From: Bloomer, David <David.Bloomer@lancashire.gov.uk>
Sent: 06 March 2018 09:17
To: Robert Major
Cc: Lancaster, Jason; planning
Subject: App3/2018/0115Malt Kiln Brow, Chipping

The above application for discharge of conditions to planning application 14/0183 has 2 highway related planning conditions, the estate lighting design and the extension of the speed limit.

CLIENT	CHIPPING HOMES LTD		
PROJECT	CHURCH RAIKE, CHIPPING		
DRAFTER	MD	ENGINEER	PG
TITLE	S38 HIGHWAYS WORKS GA		
SCALE	SHEET	DRAWING No	REV
1:500	A1	3081-SHD-00-ZZ-DR-C-0218	P2

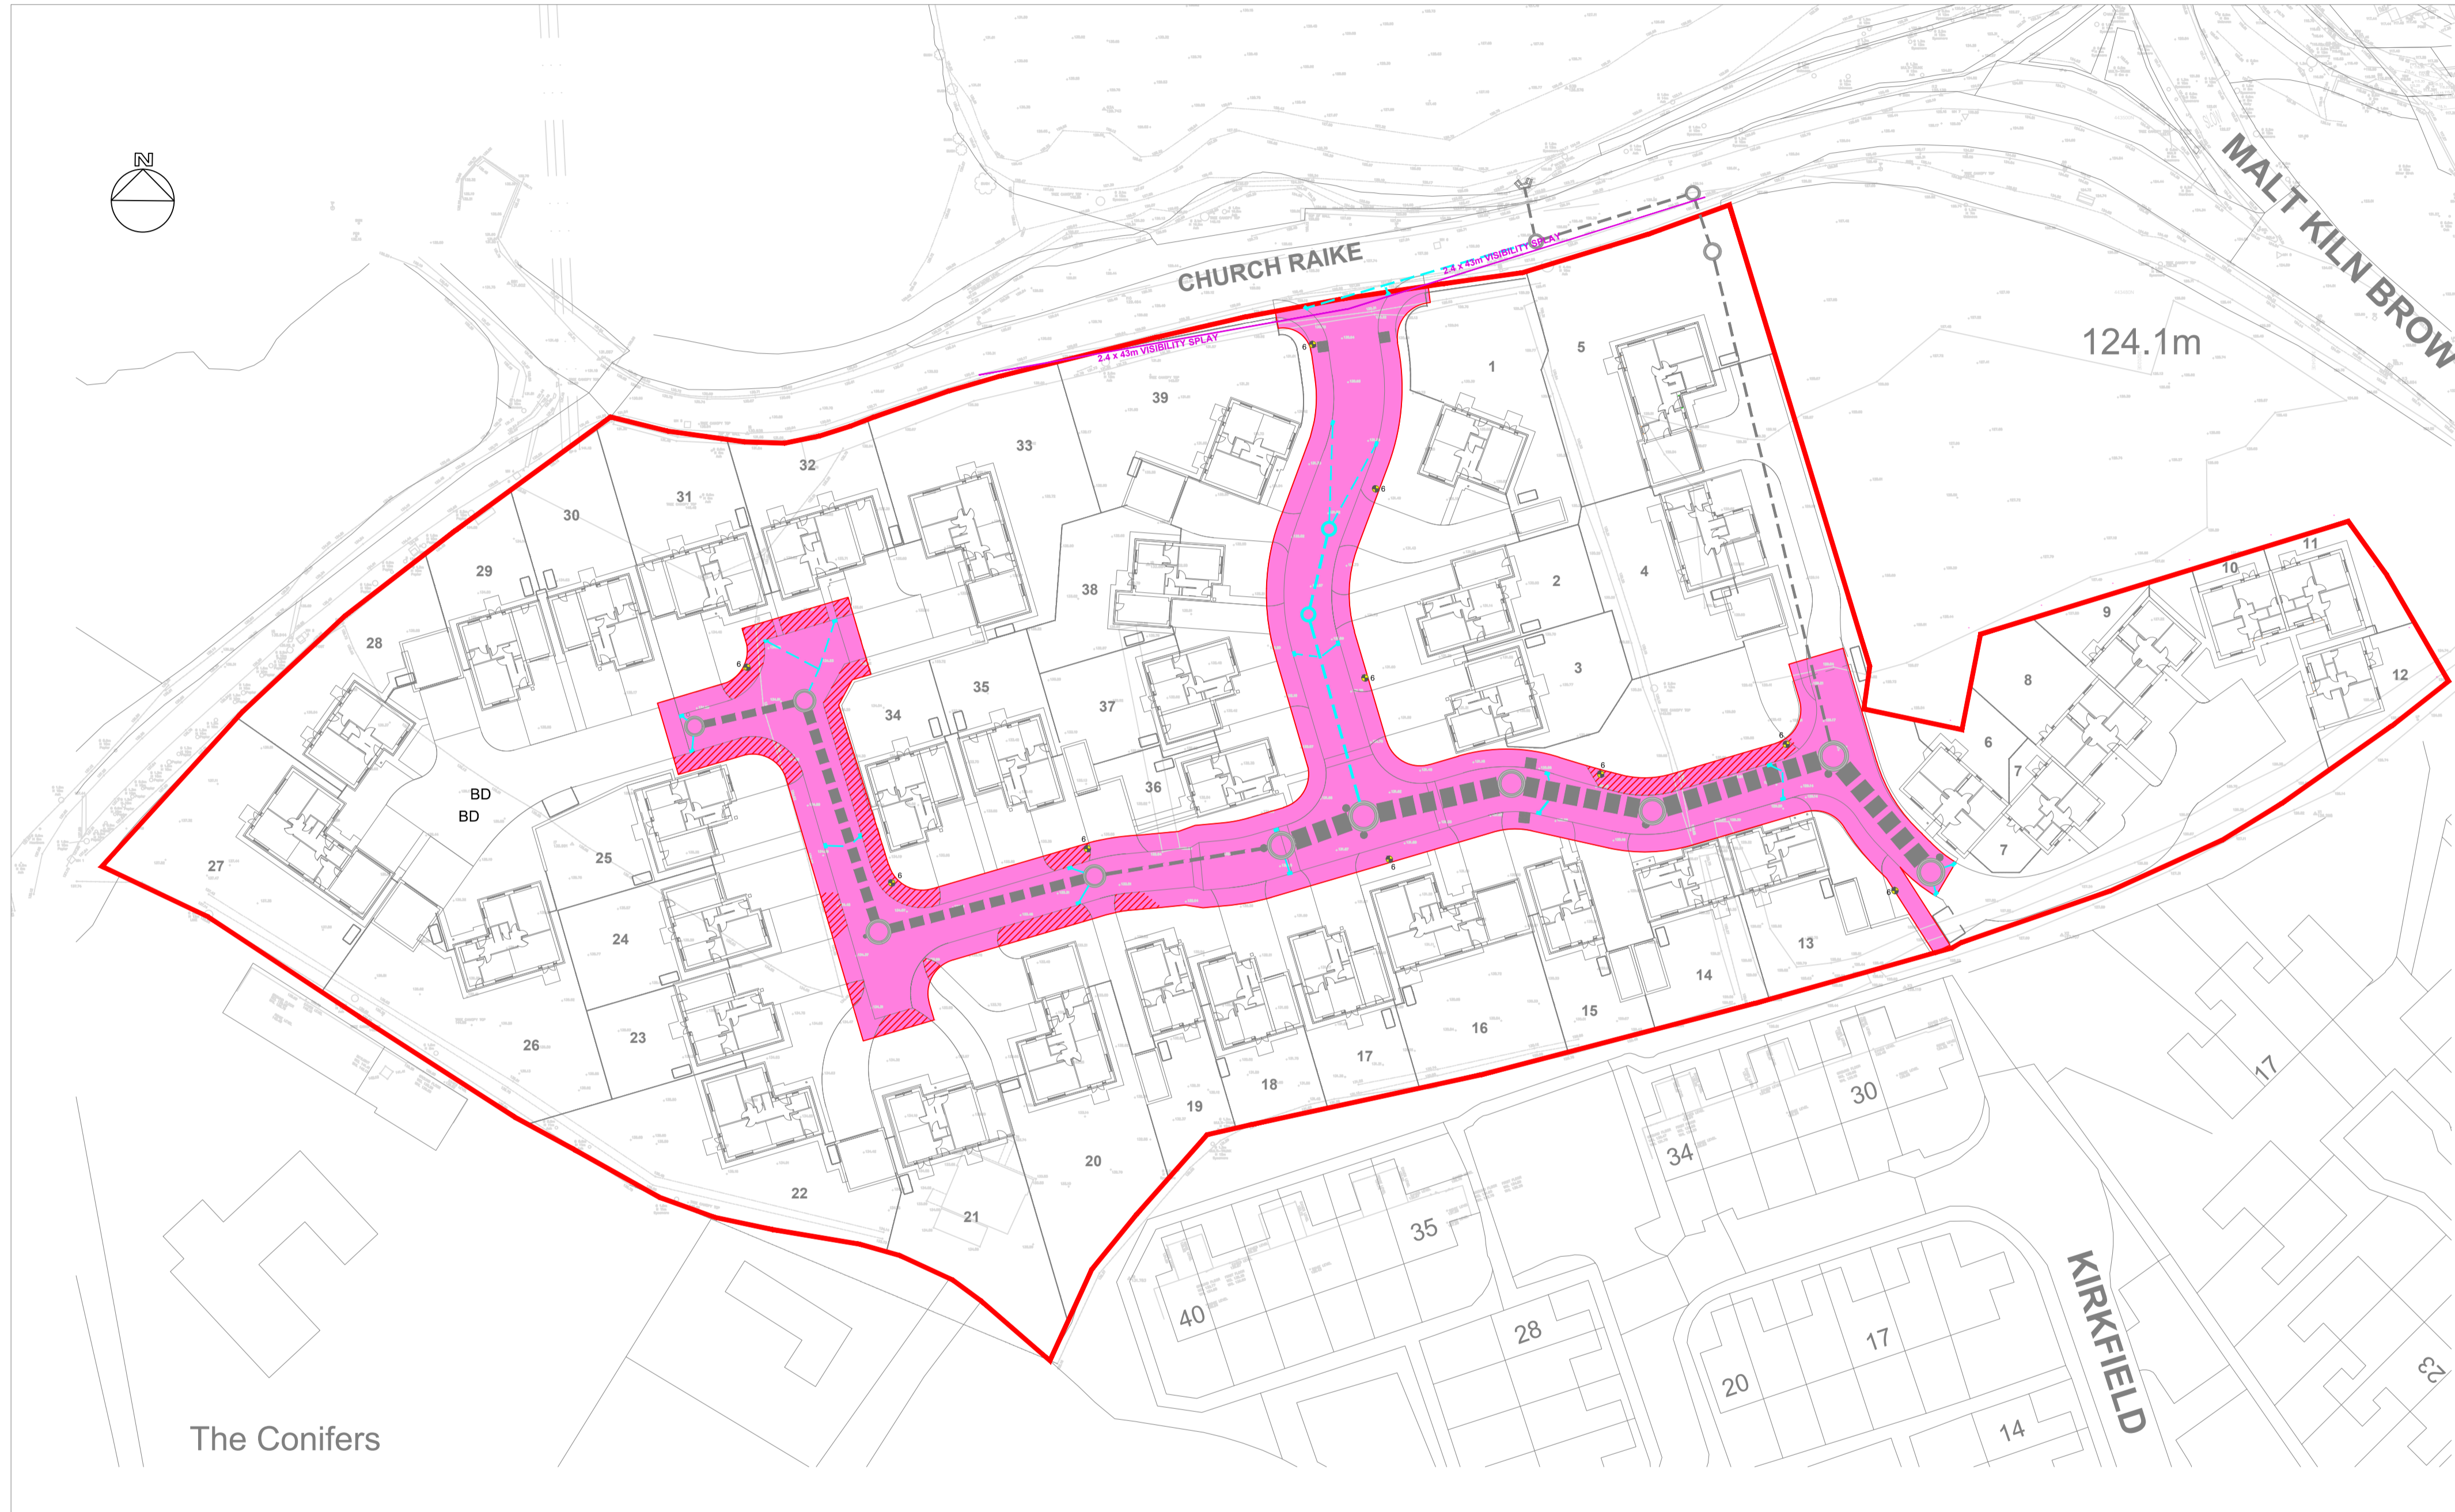
In respect of the street lighting condition, I can confirm that the S38 agreement is progressing but not yet signed. However the street lighting design was prepared by LCC and in that respect the design would be acceptable.
